Our Ref: EP/120/18/PL

**Town & Country Planning Act 1990 (as amended)
Town and Country Planning (Development Management Procedure) (England) Order 2015
Application for Planning Permission**

Development Change of use of boat store & sail loft (Sui Generis) to 1 No. dwelling (C3 Dwelling house).

Location The Loft 129 Sea Road East Preston

131 Sea Road, East Preston, Littlehampton, BN16 1PD

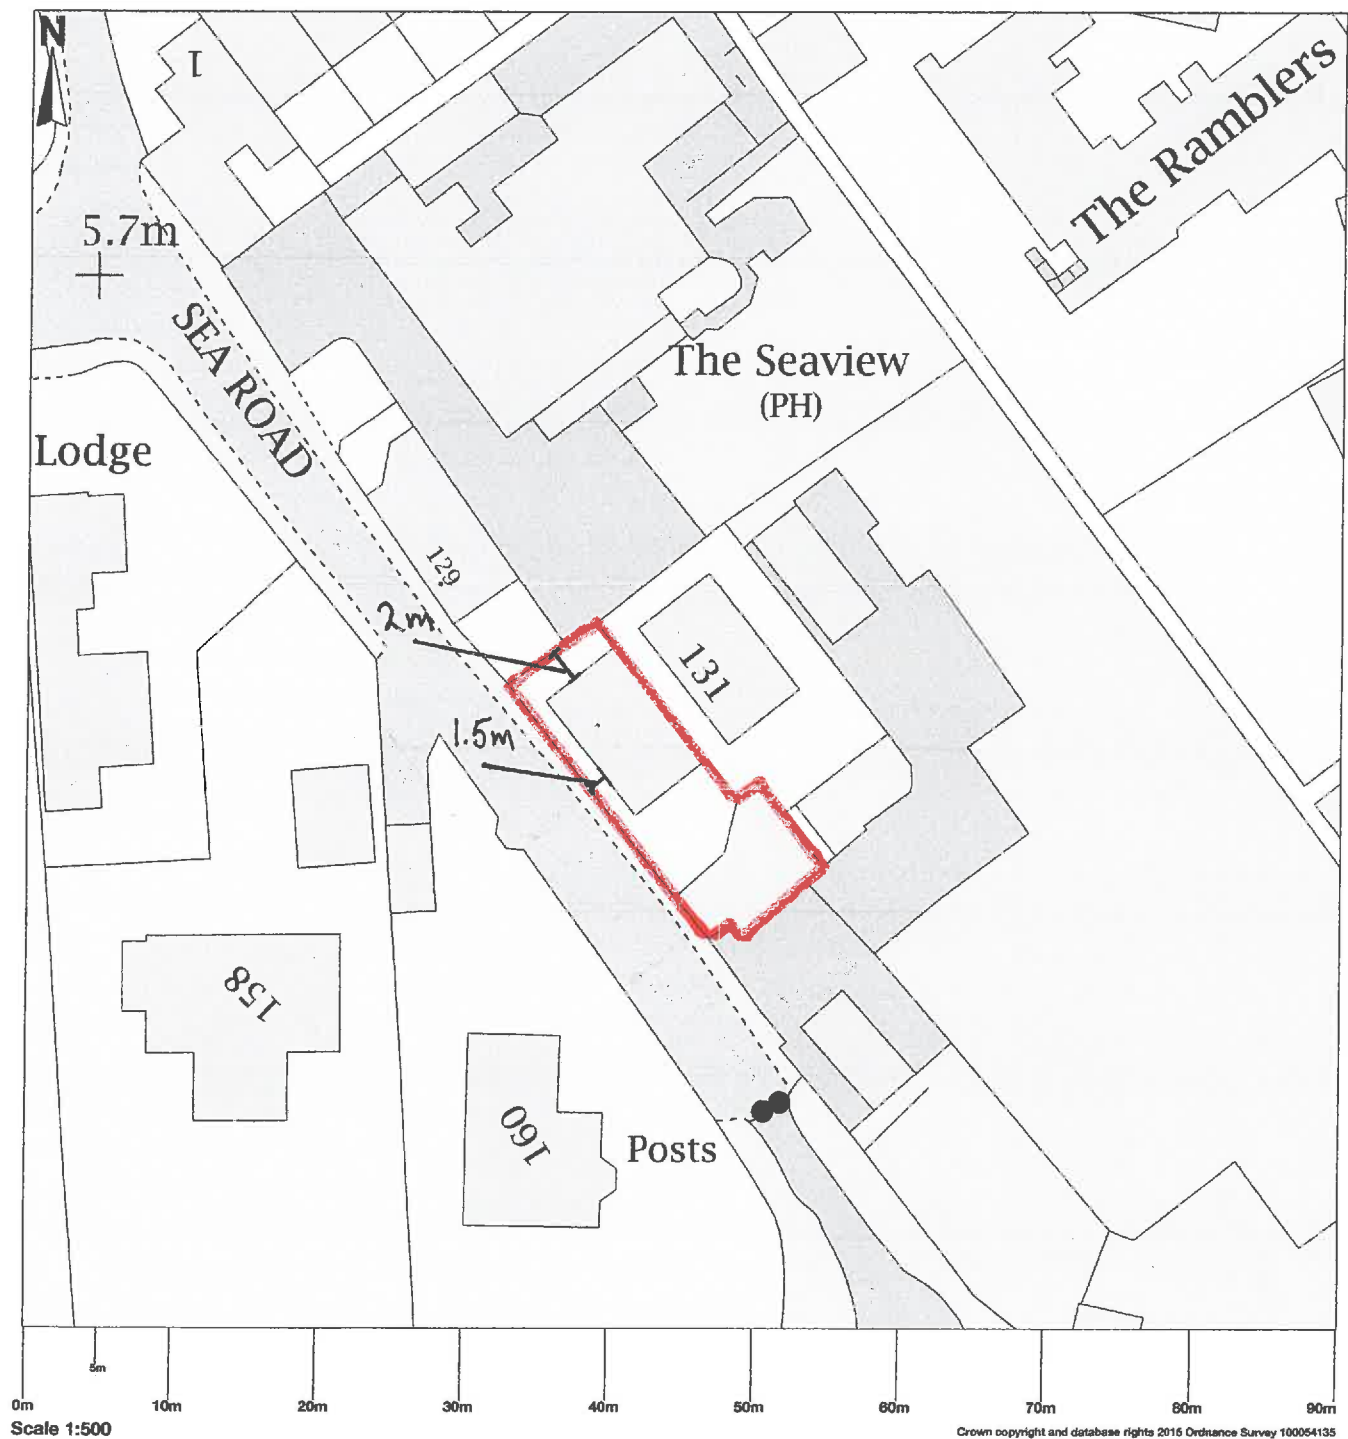
On the proposed site plan, please show the position of the bins.

Ordinance Survey © Crown Copyright 2018. All rights reserved.
Licence number 100022432. Plotted Scale - 1:1250

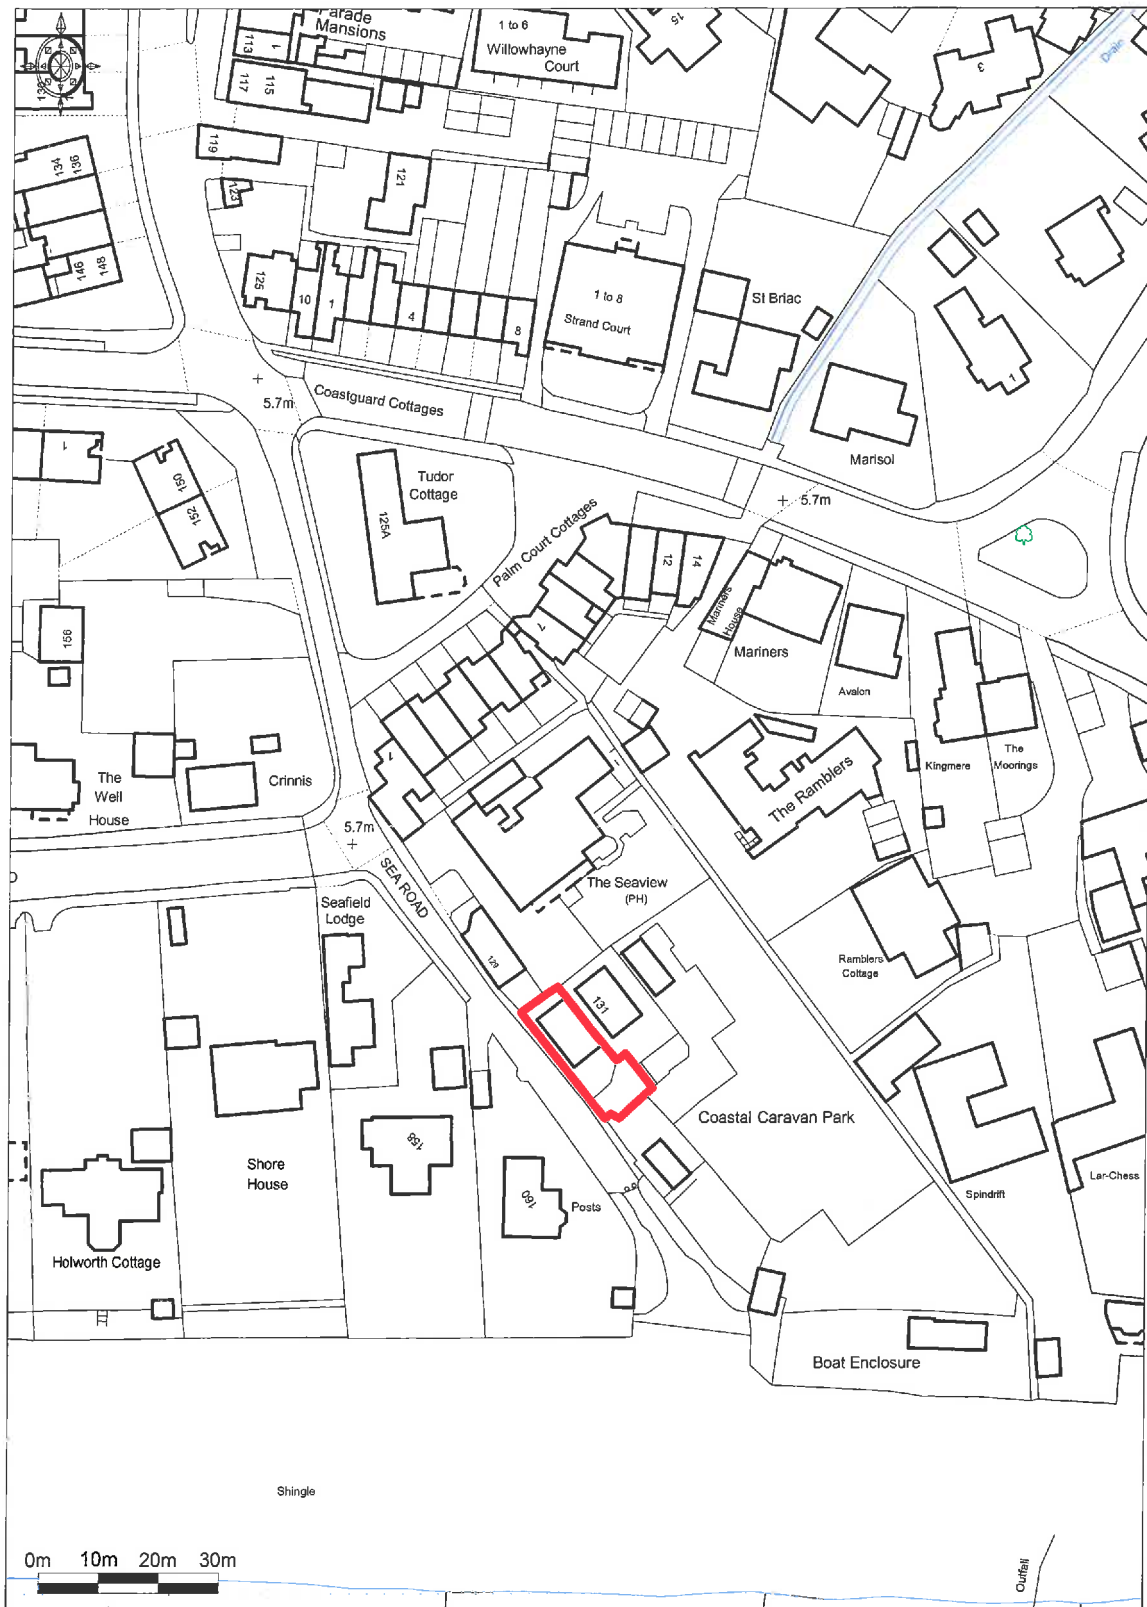
The site address on the application form is 129 Sea Lane while the red edge on the location plan is around 131A Sea Lane. Please amend as necessary.
